5 September 2025

RE: Residential flat building with in-fill affordable housing - 19 - 25 Balfour Street, Lindfield; SSD-82709458

Drawn:
**OVERSHADOWING DIAGRAMS
(PROPOSED)**

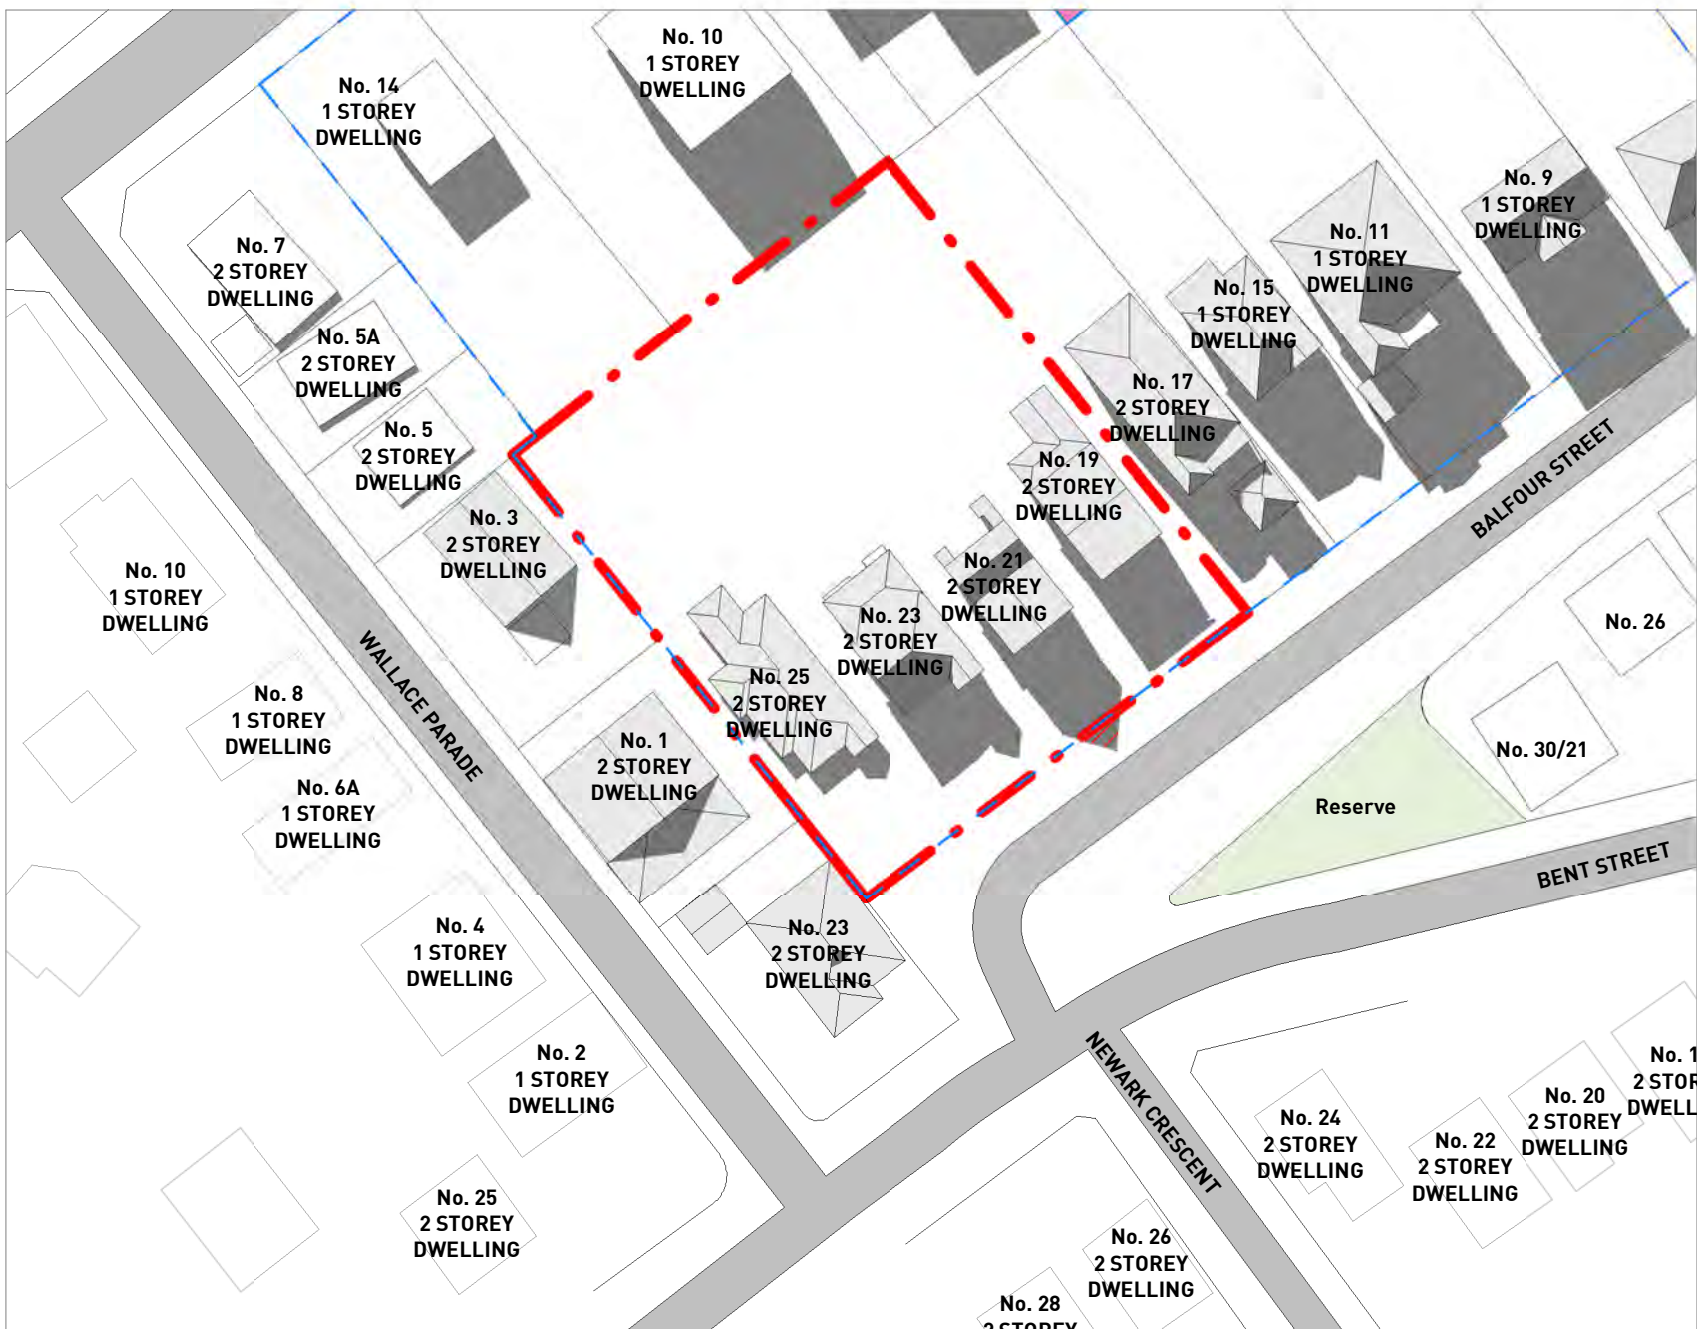
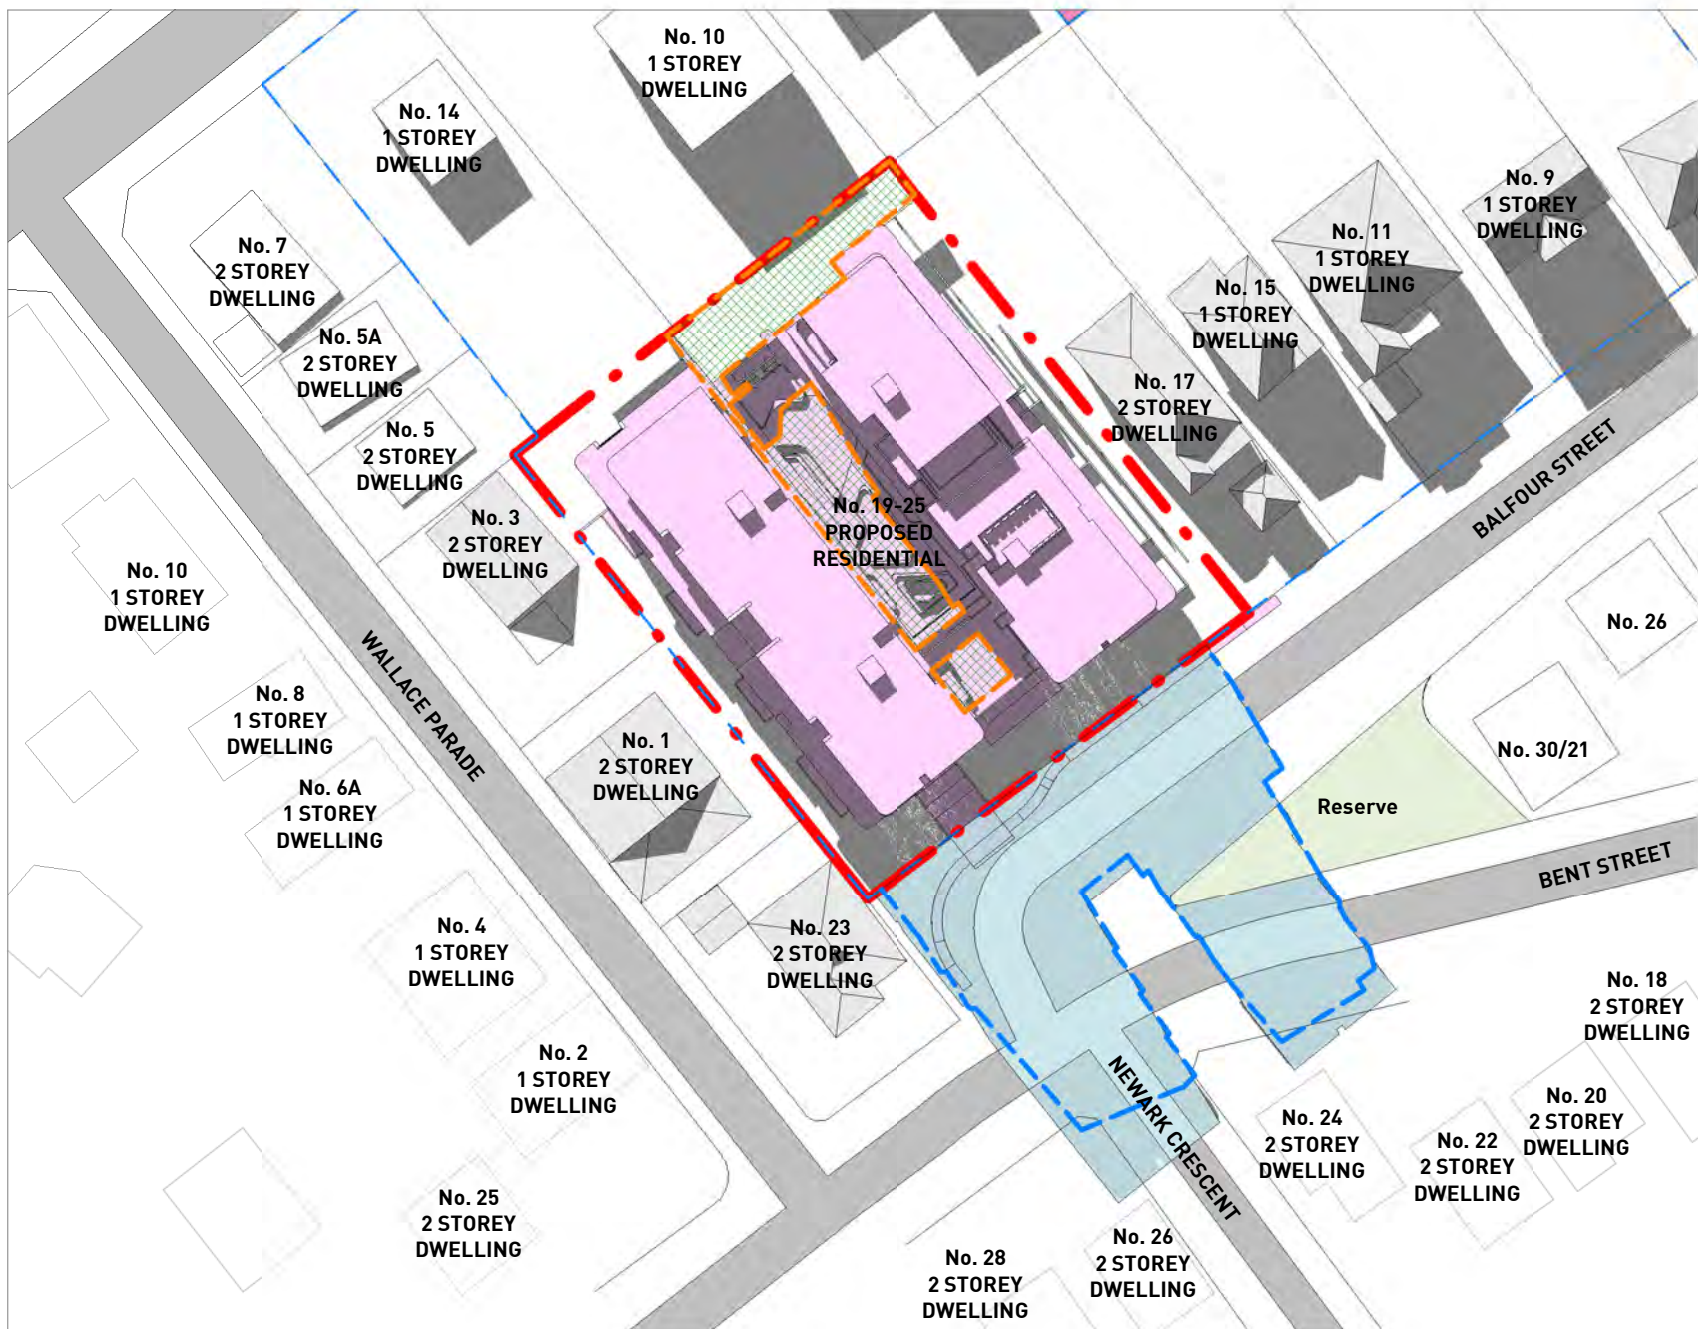
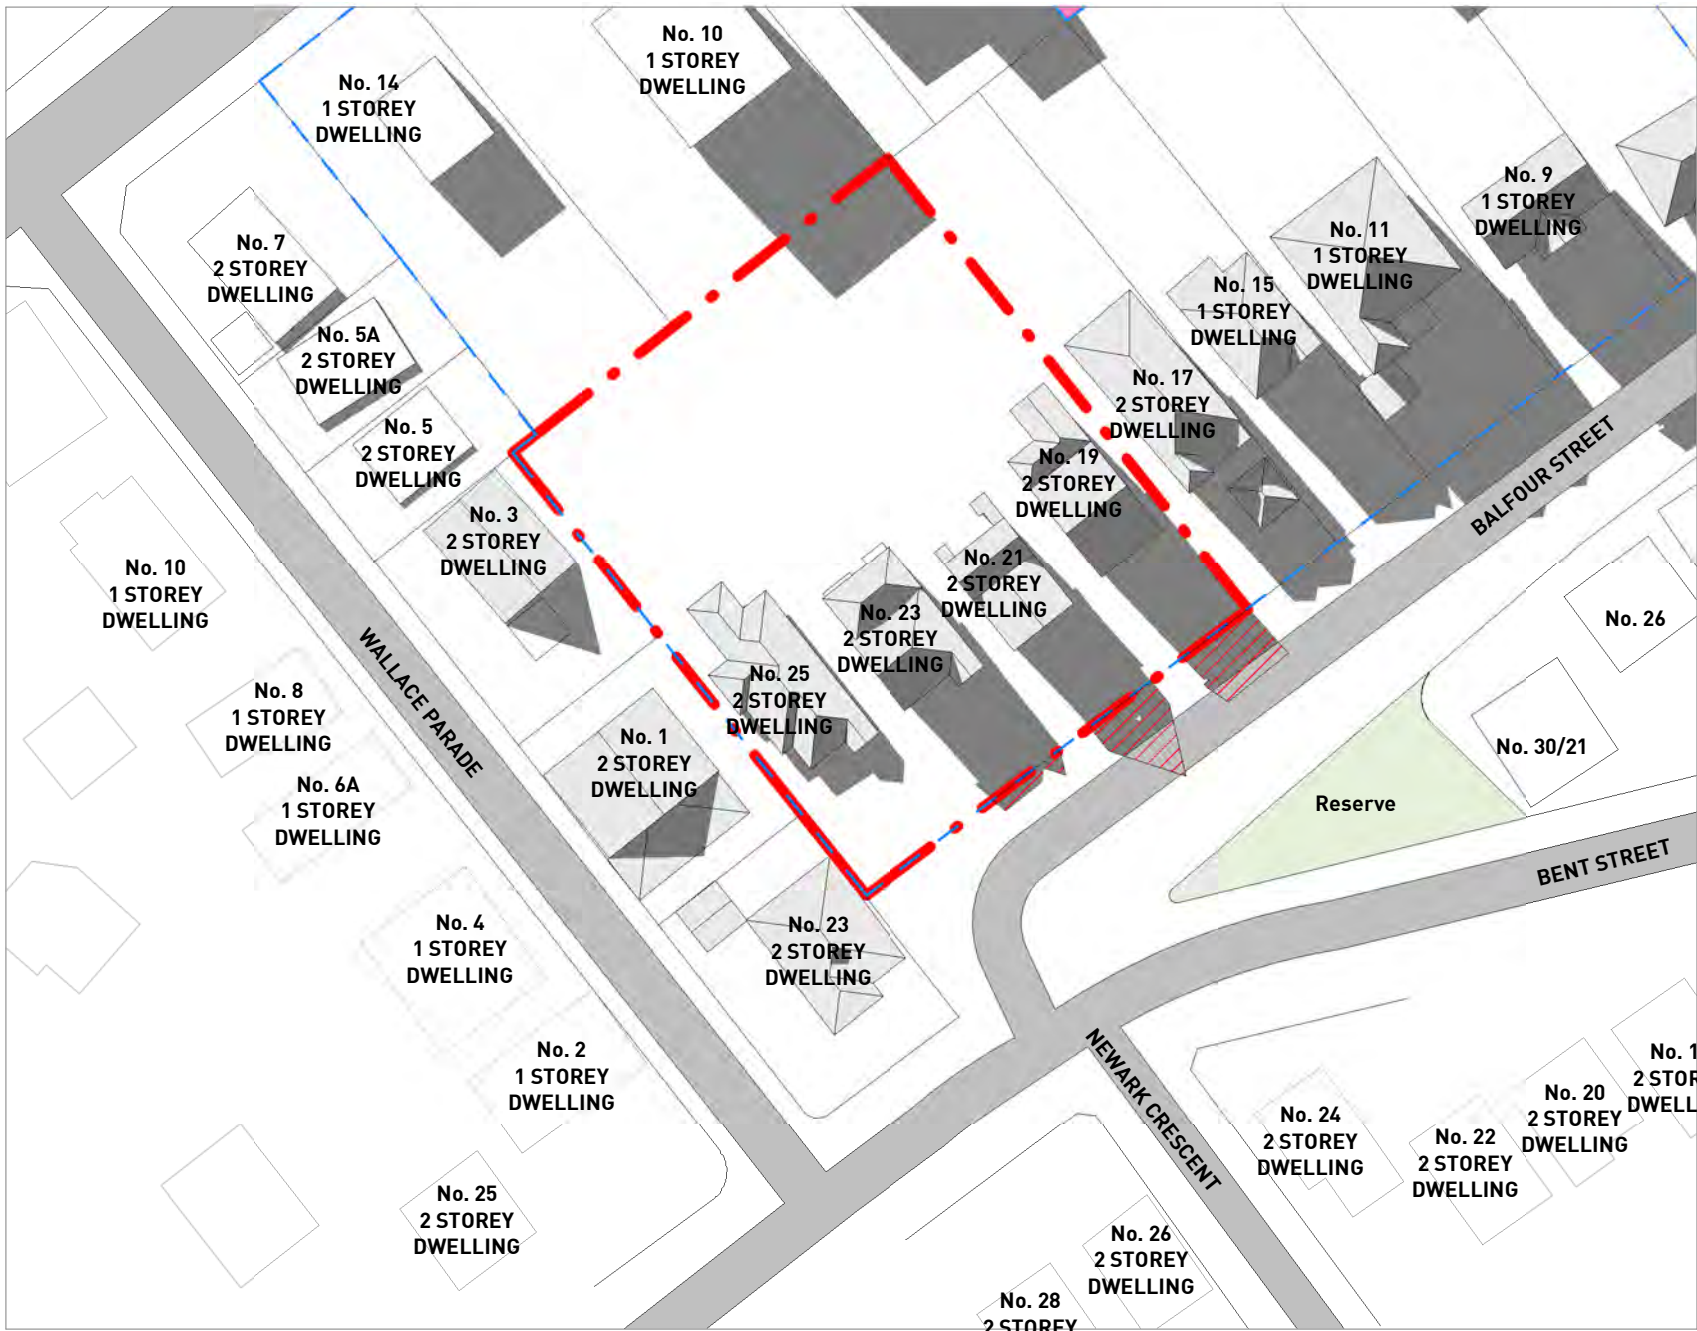
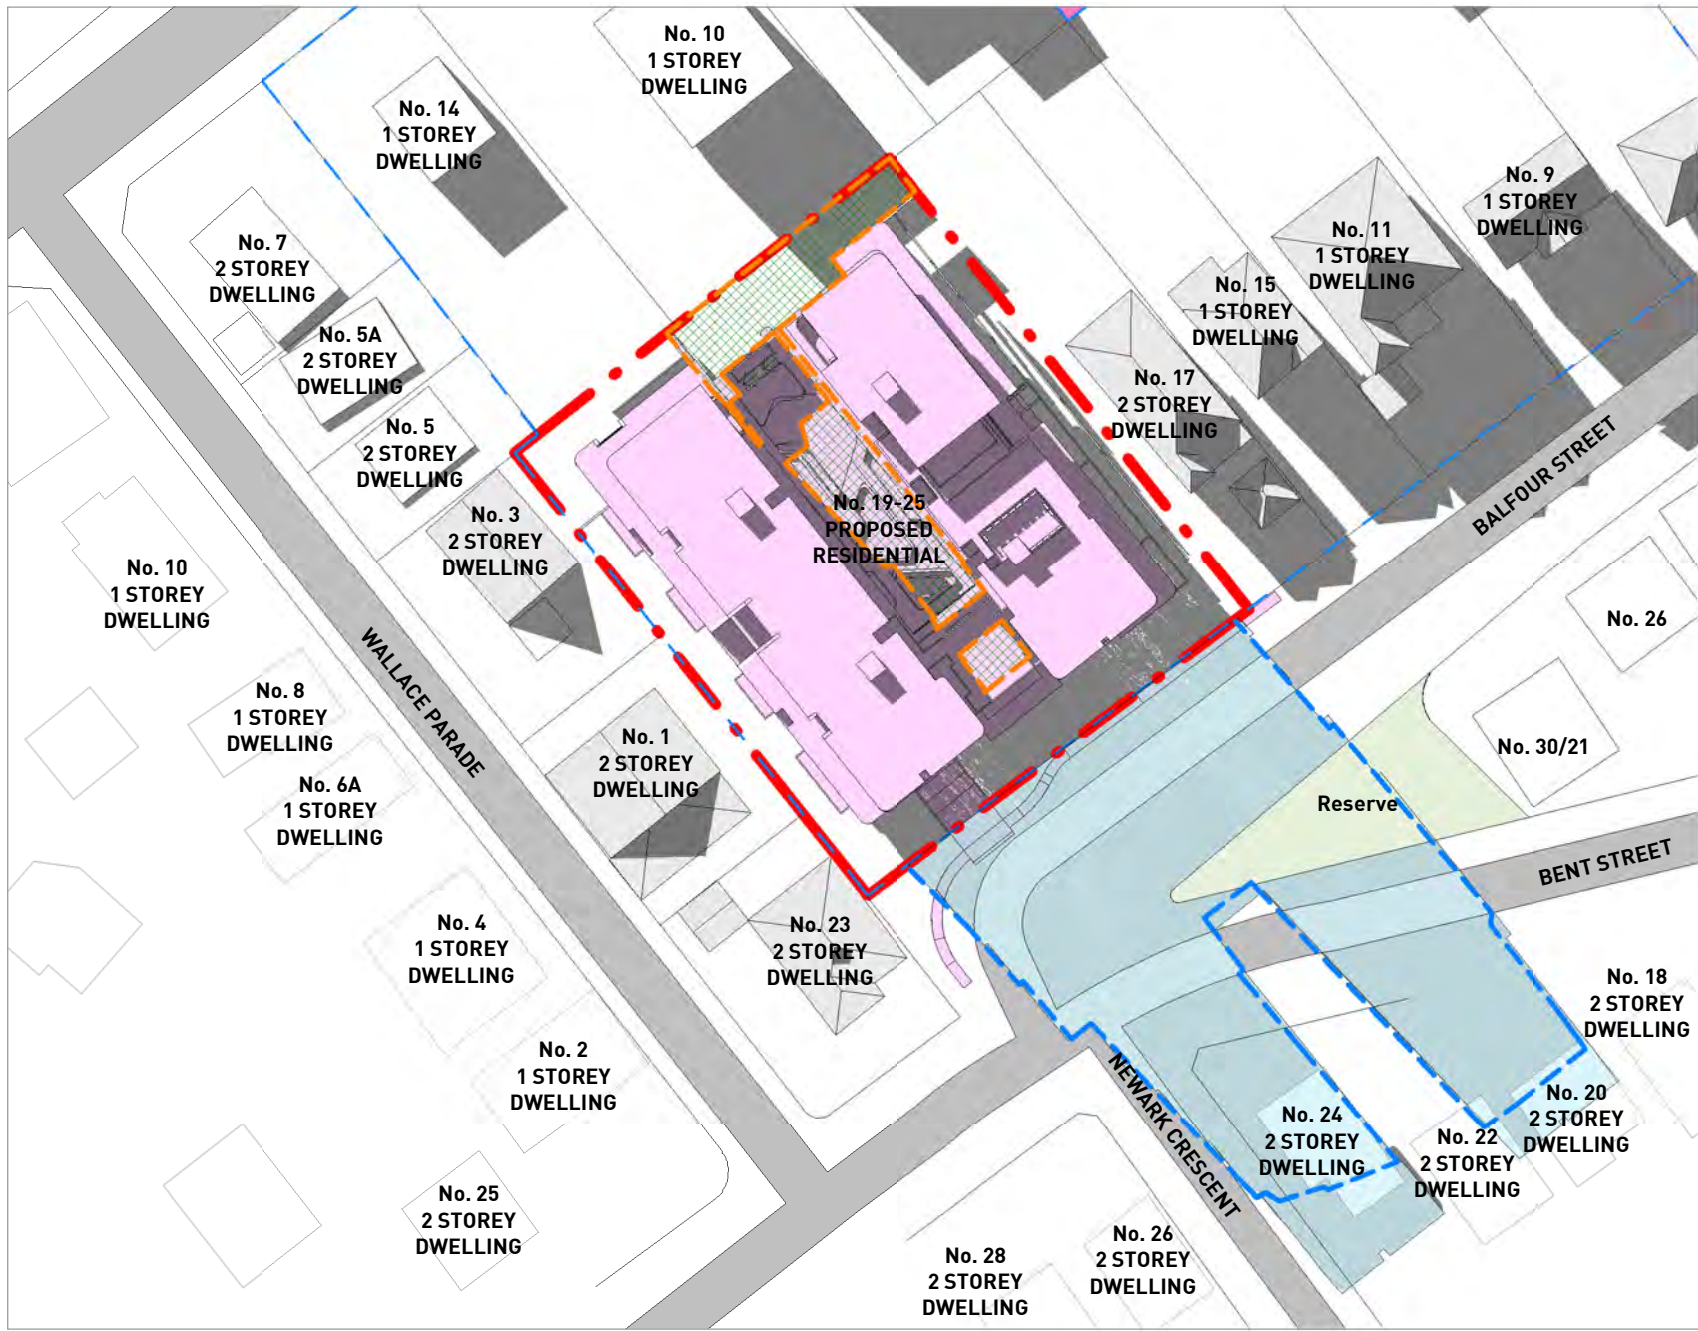
The application’s shadow analysis (Architectural Design Report of Giles Tribe dated 14 July 2025 at page 19) models 21 June and shows:

- Western neighbours: “Buildings to the west benefit from at least two hours of sunlight between 1:00 pm and 3:00 pm.” In other words, only 2 hours of sun within the 9 am–3 pm assessment window, below the typical KDCP objective that adjoining low-density dwellings retain 3 hours to living rooms and principal private open space.
- Southern neighbours (Bent St): “...are only affected by overshadowing around 3:00 pm.” This removes late-afternoon sun at the end of the 9 am–3 pm window, which is critical for winter amenity.
- The diagrams are “shadow cast on approximate ground level” (page 19). They do not assess upper-storey living rooms/terraces on neighbouring houses; given the 9-storey height and tight side setbacks, overshadowing to west-facing POS and habitable windows at higher levels is likely greater than suggested by ground-plane projections.

For completeness: the applicant’s June-21 diagrams do not show material mid-winter shadowing to properties to the north-east; the unacceptable overshadowing is borne by the western and southern interfaces and the public domain. The proposal still fails the KDCP solar-access objective for adjacent low-density dwellings and delivers only marginal internal ADG solar outcomes.
